## Post Construction Stormwater Management Applicability Evaluation Form

Part I. Project Information	
1. Project Name: Rocky Top Motel and Campground	
2. El Paso County Project #: PPR2140	3. ESQCP #:
4. Project Location: 10090 W Hwy 24	Project Location in MS4 Permit Area (Y or N): <span style="background-color: #ffcc99; padding: 2px;">No</span>
5. Project Description: Existing motel and campground	What happened to the description that was here on the previous submittal? Please add it back in.
If project is located within the El Paso County MS4 Permit Area, please provide copy of this completed form to the Stormwater Quality Coordinator for reporting purposes; and save completed form with project file.

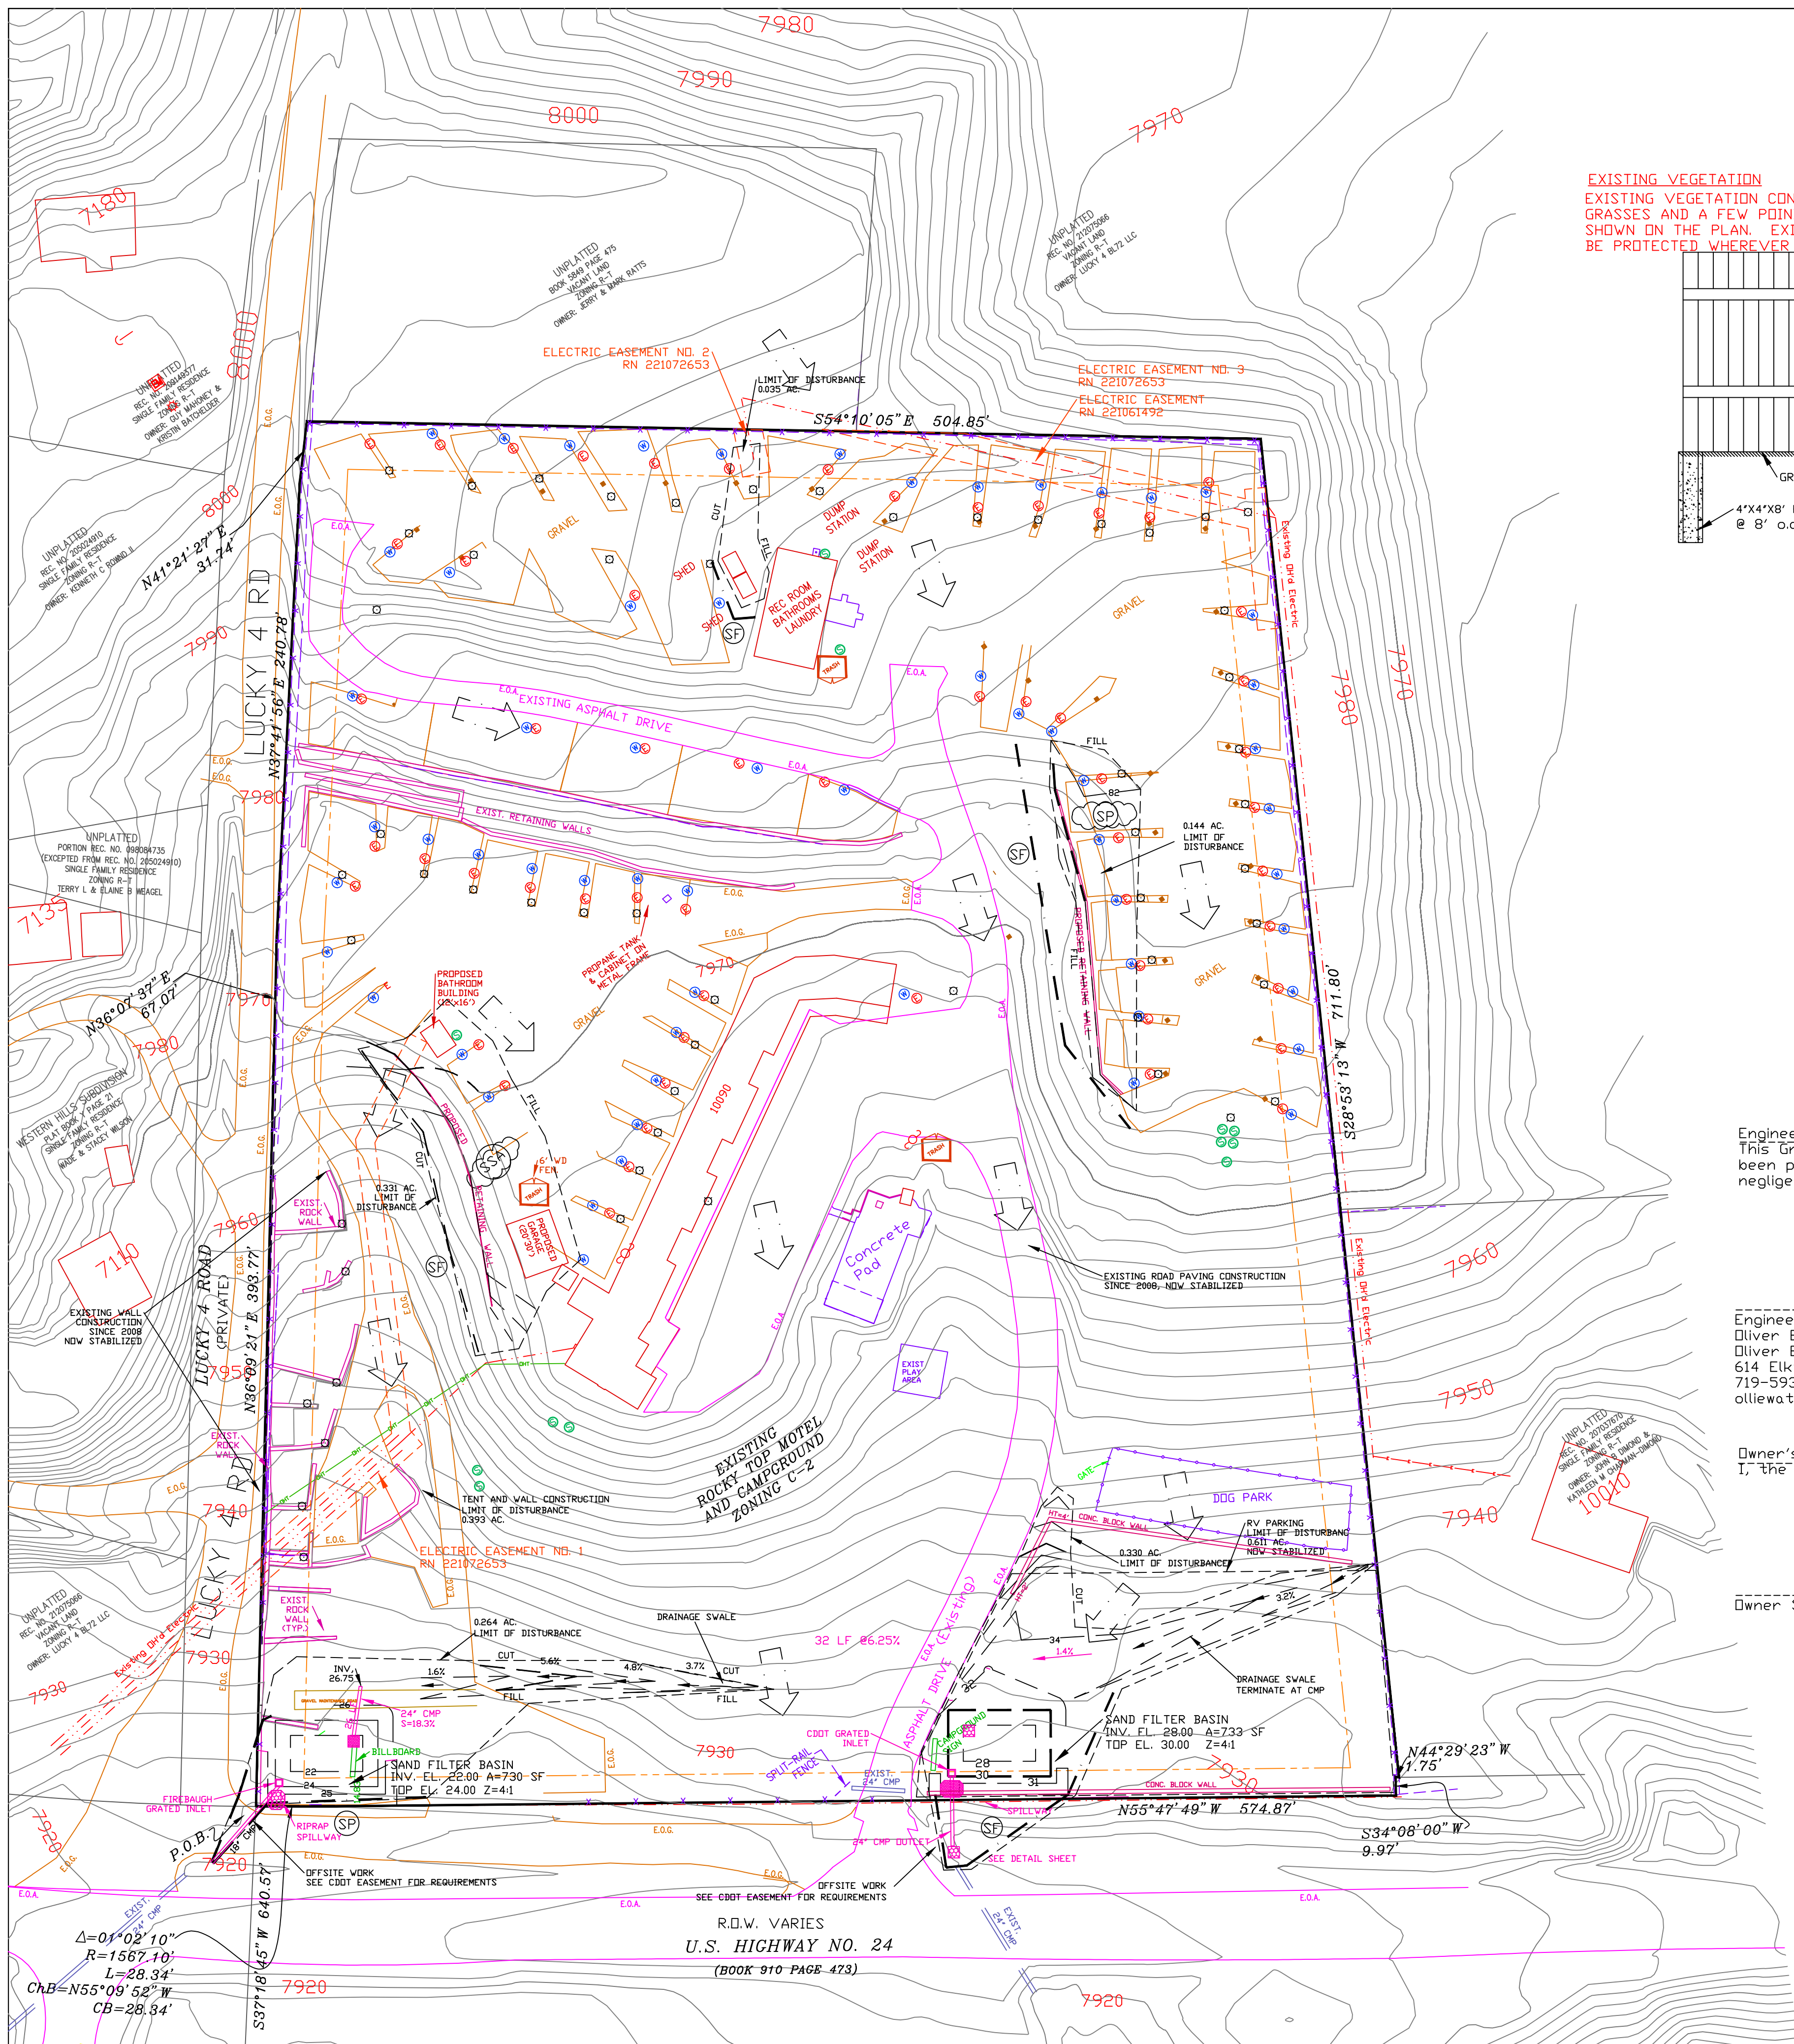
Unresolved previous comment:  
Revise to "Yes" since two SFBs  
are providing WQCV.
